### **Final Report - Corrections Required** **Application No. ANEX-24-0006**

**Description : Matrix Design Group on behalf of Colorado Springs Equities LLC is submitting a serial annexation petition for seven parcels and Land Use Plan/Rezoning exhibit for a portion of the subdivision known as Rock Creek Mesa.**

**Document Filename : Rock Creek Mesa Addition No 5\_Annexation Plat\_V3\_5-13-24**

ROCK CREEK MESA ADDITION NO. 5

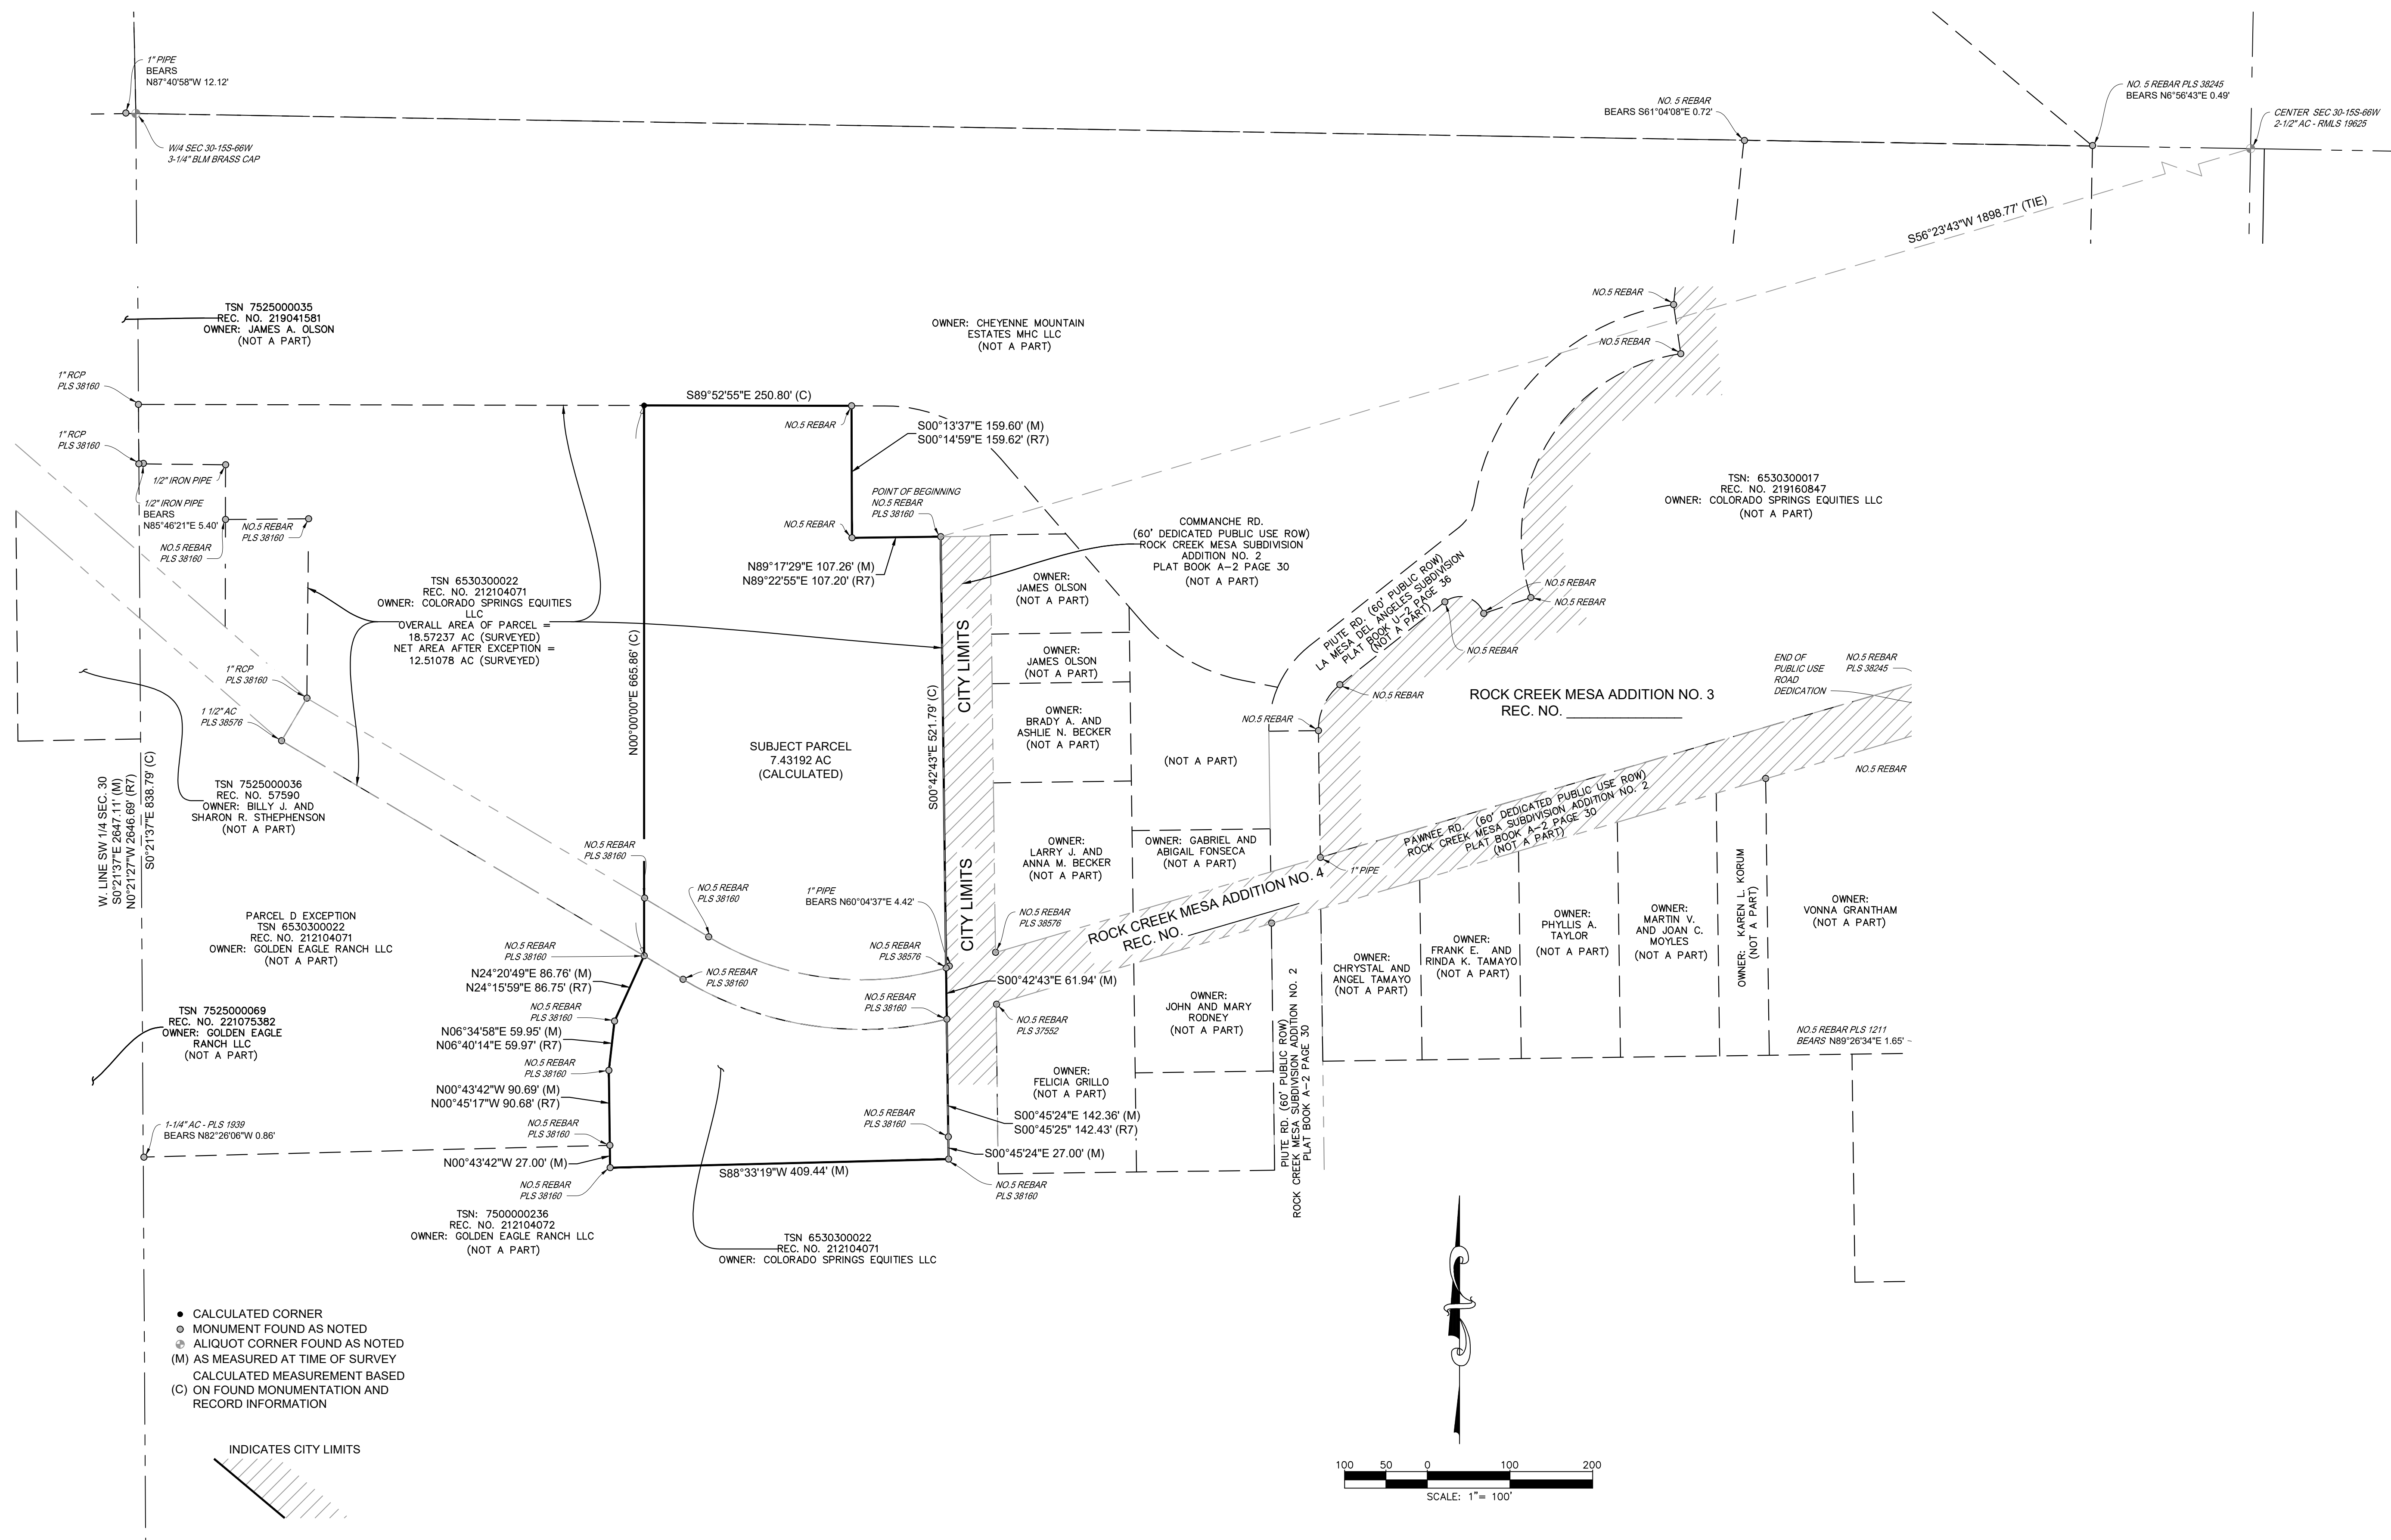
38	2	Cory Sharp : Planning	N 89-17-36 E closure sheet
39	2	Cory Sharp : Planning	this distance is needed for the contiguous calculation
40	2	Cory Sharp : Planning	add the line for Addition No. 4
41	2	Cory Sharp : Planning	does the remainder of the street need to be annexed?
42	2	Cory Sharp : Planning	Please label Pawnee included where the end of the platted right-of-way ends and the information of the unplatted right-of-way
44	2	Cory Sharp : Planning	please consider adding the point of commencing to the center of section and adding the tie to the legal description. (please add that information on all the additions that are showing said information, the comment might have been missed on previous additions, please add accordingly to all that it applies to)

Please label Pawnee included where the end of the platted right-of-way ends and the information of the unplatted right-of-way

Please add a general note to confirm the establishment of an appropriate easement(s) through a final plat for the existing OH electric (12.5kV Primary OH Conductor: CSU #12JL-1) running through portions of Addition Nos. 3, 5 and 6 or if it is to be relocated as part of the proposed future development.

this distance is needed for the contiguous calculation

does the remainder of the street need to be annexed?

add the line for Addition No. 4
